# Development Application and Planning Proposal Review NSW Planning Portal Concurrence and Referral

Address	Land Title
20 Kelso Crescent, Moorebank	Lot 2 DP 521146, Lot C DP 327378

Environmental Impact Statement (EIS) for the Kelso Crescent Multi-Level Warehouse, Moorebank. Demolition of existing onsite structures and construction and operation of a multi level warehouse and distribution centre, comprised of five tenancies, with mezzanine offices and parking, and associated vehicular access.

0 5 10 20 30 40 50
GRAPHIC SCALE 1:500
purpose DEVELOPMENT APPLICATION
GROUND FLOOR / SITE PLAN

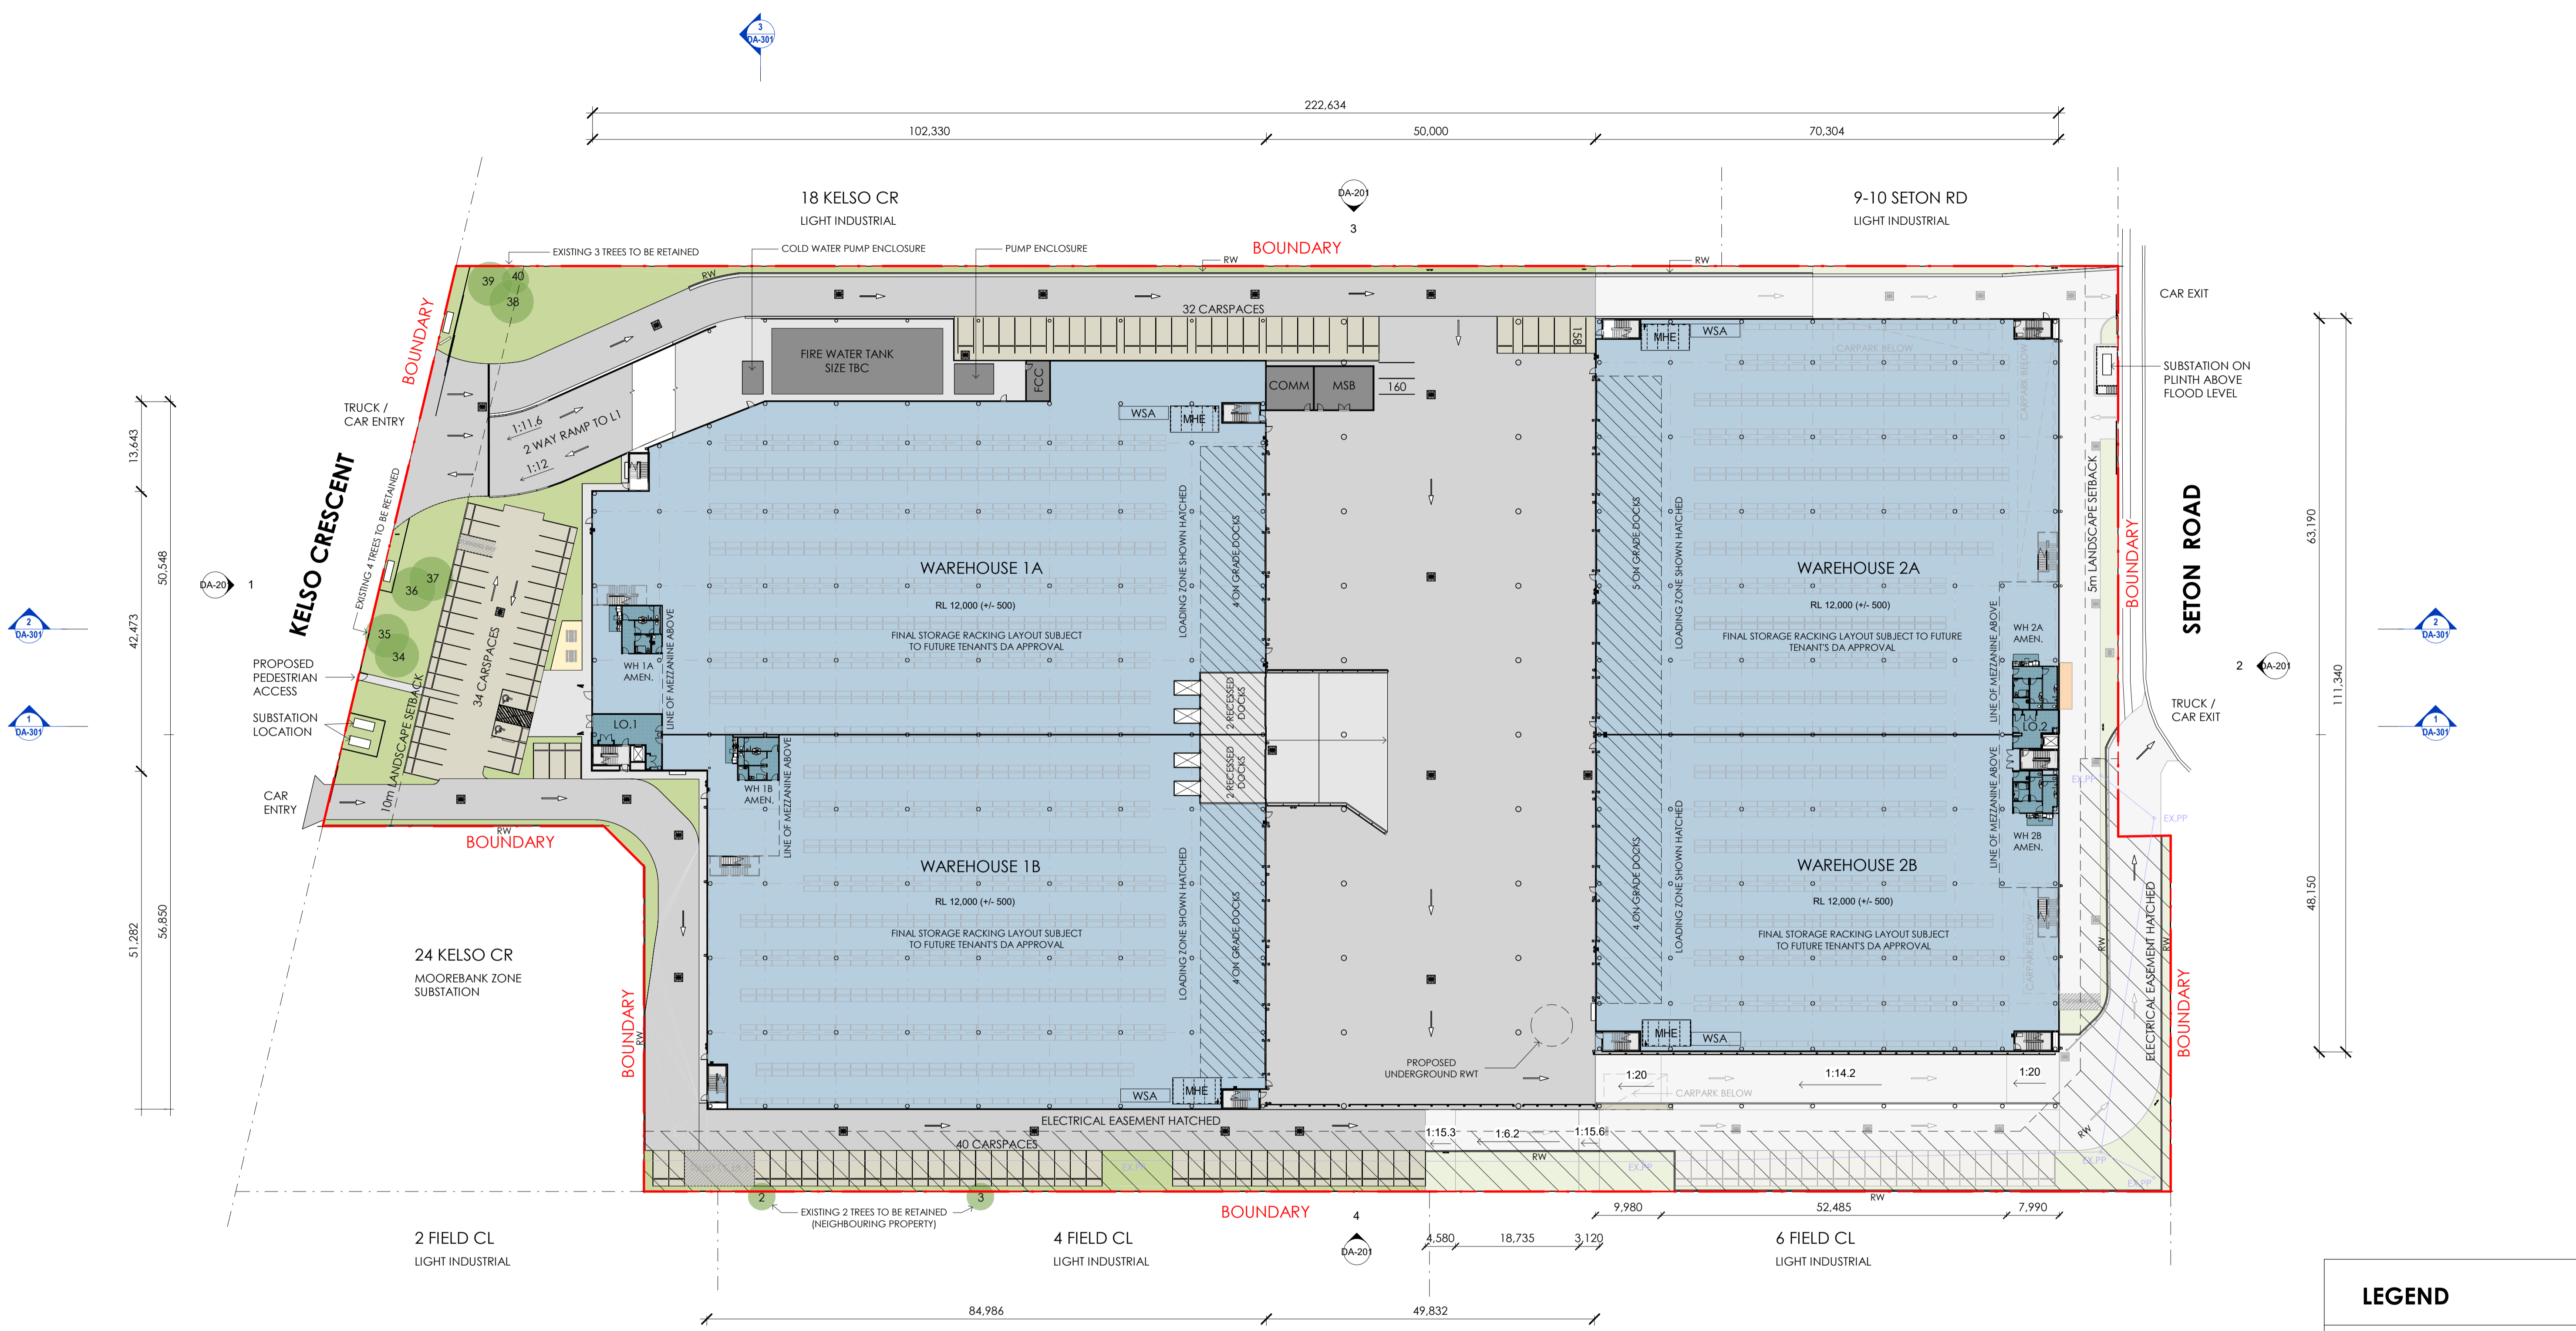
- The following extract of the Site & Roof Plan shows the two padmount substations in a different location to the two options shown in Building Services Infrastructure Report. Although there is no dimension shown on the plan, appropriate regard must be had to the required restriction / clearance for fire rating shown in Endeavour Energy's Mains Design Instruction MDI 0044 'Easements and Property Tenure Rights', Figure A4.3 'Padmount easements and clearances'.
